Current Zoning: UR-2(CD) (Urban Residential, Conditional), N2-B (Neighborhood Residential)
Proposed Zoning: UR-2(CD) (Urban Residential, Conditional), UR-2(CD) SPA (Urban Residential, Conditional, Site Plan Amendment)

Approximately 7.01 acres located south of Alleghany Street, west of Ashley Road, and north of Bullard Street.

The petition proposes to amend a previously approved plan to allow a community of 123 single family attached dwelling units in the Ashley Park neighborhood.

RZ-2

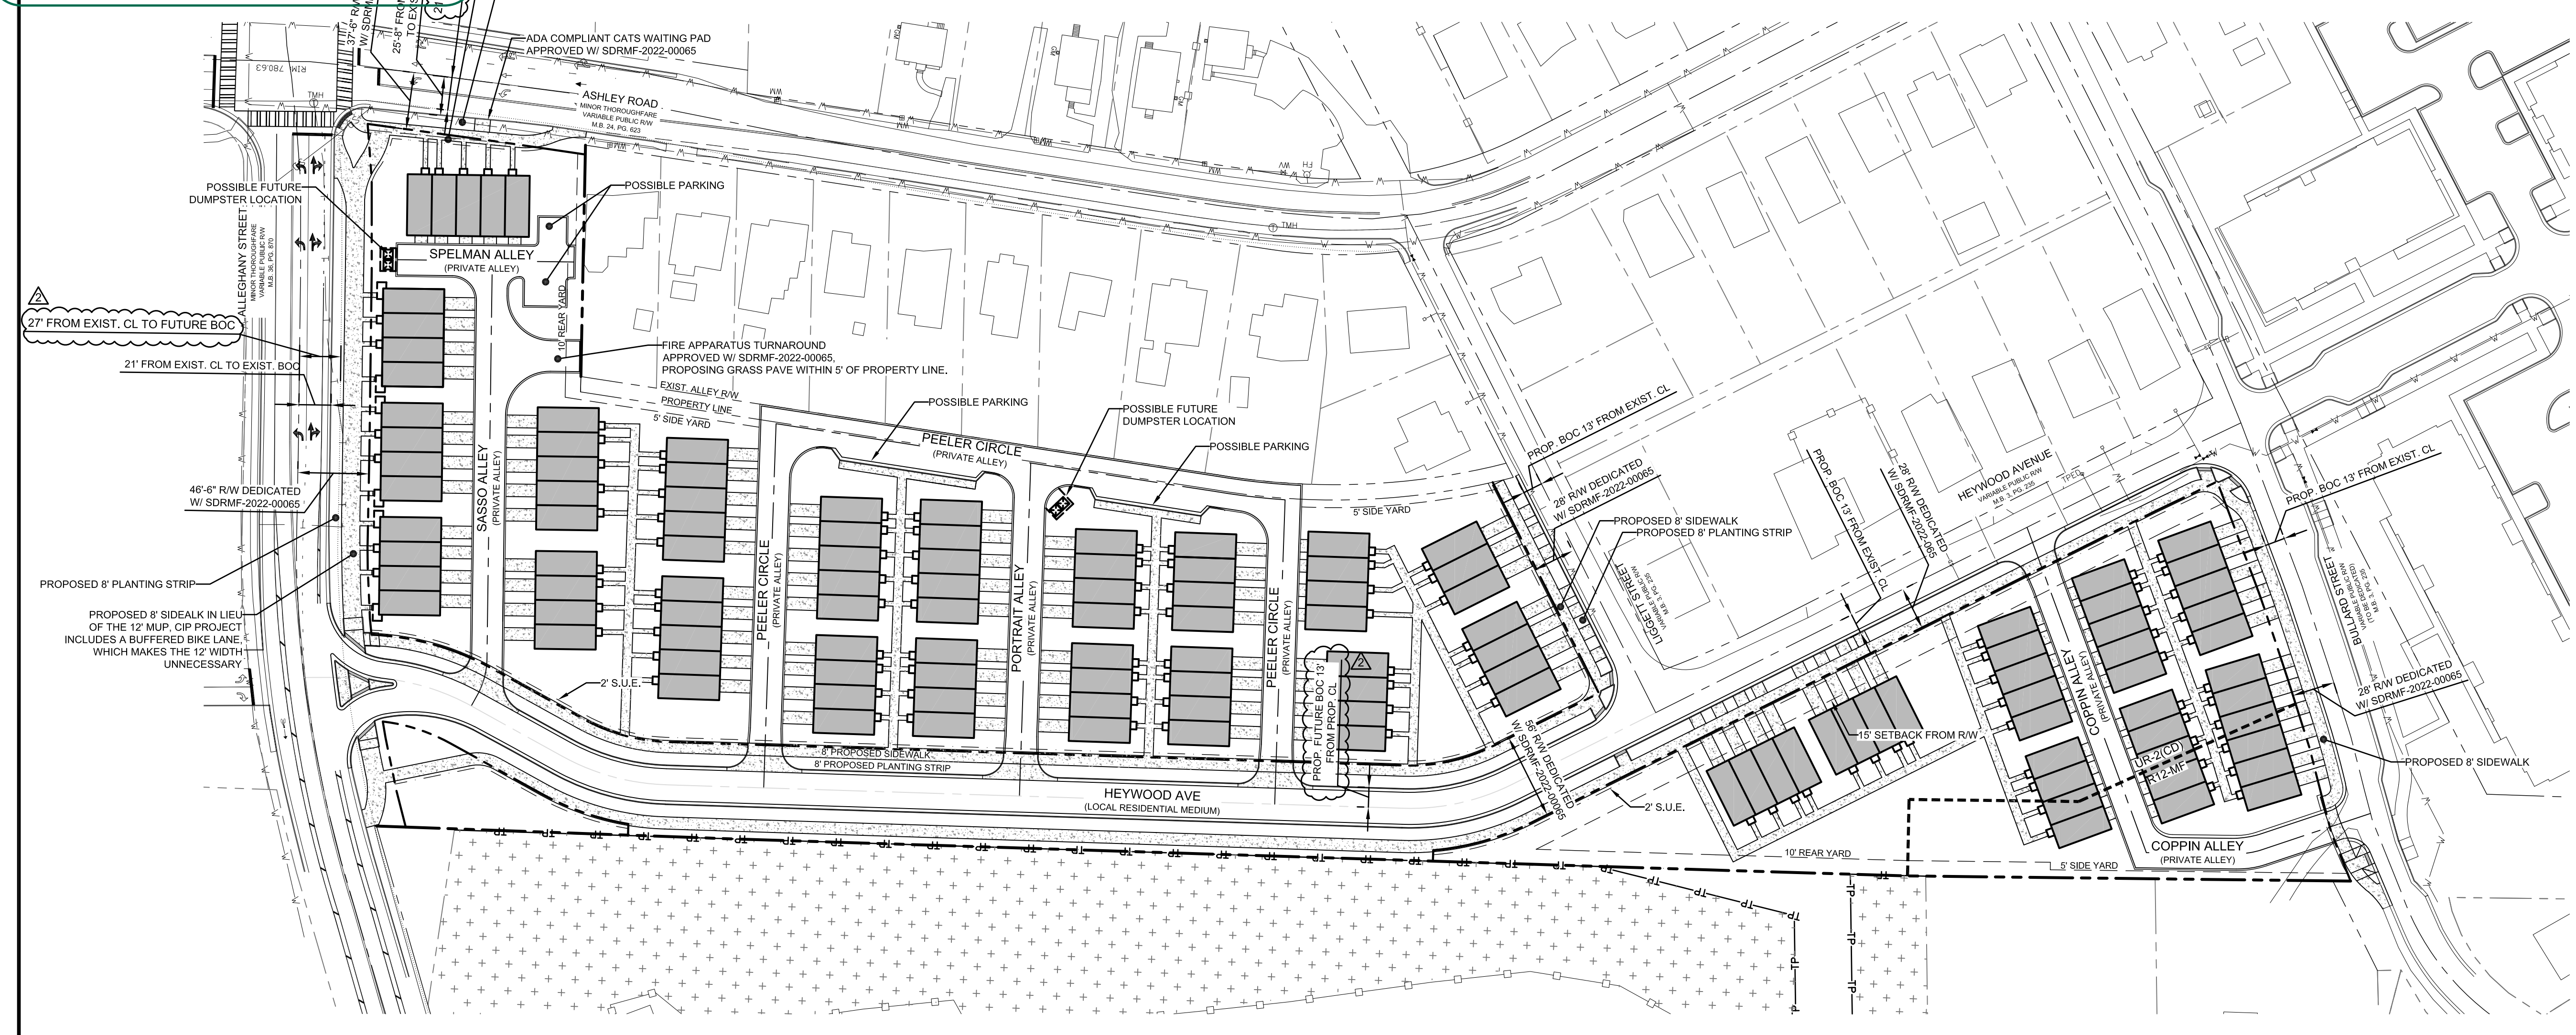
1. ~~Label and dimension the future curb and gutter from the centerline for each road on the site plan.~~ **ADDRESSED**
2. ~~Add a conditional note specifying "A Right-of-Way Encroachment Agreement is required for the installation of any non-standard item(s) (irrigation systems, decorative concrete pavement, brick pavers, etc.) within a proposed/existing City maintained street right-of-way by a private individual, group, business, or homeowner's/business association. An encroachment agreement must be approved by CDOT prior to construction/installation. Contact CDOT for additional information concerning cost, submittal, and liability insurance coverage requirements."~~ **ADDRESSED**

4. ~~Revise site plan and conditional note(s) to remove the fence completely from the public alley and onto private property. If fence is to remain along the single family home side it needs to be completely on private property.~~ **ADDRESSED**
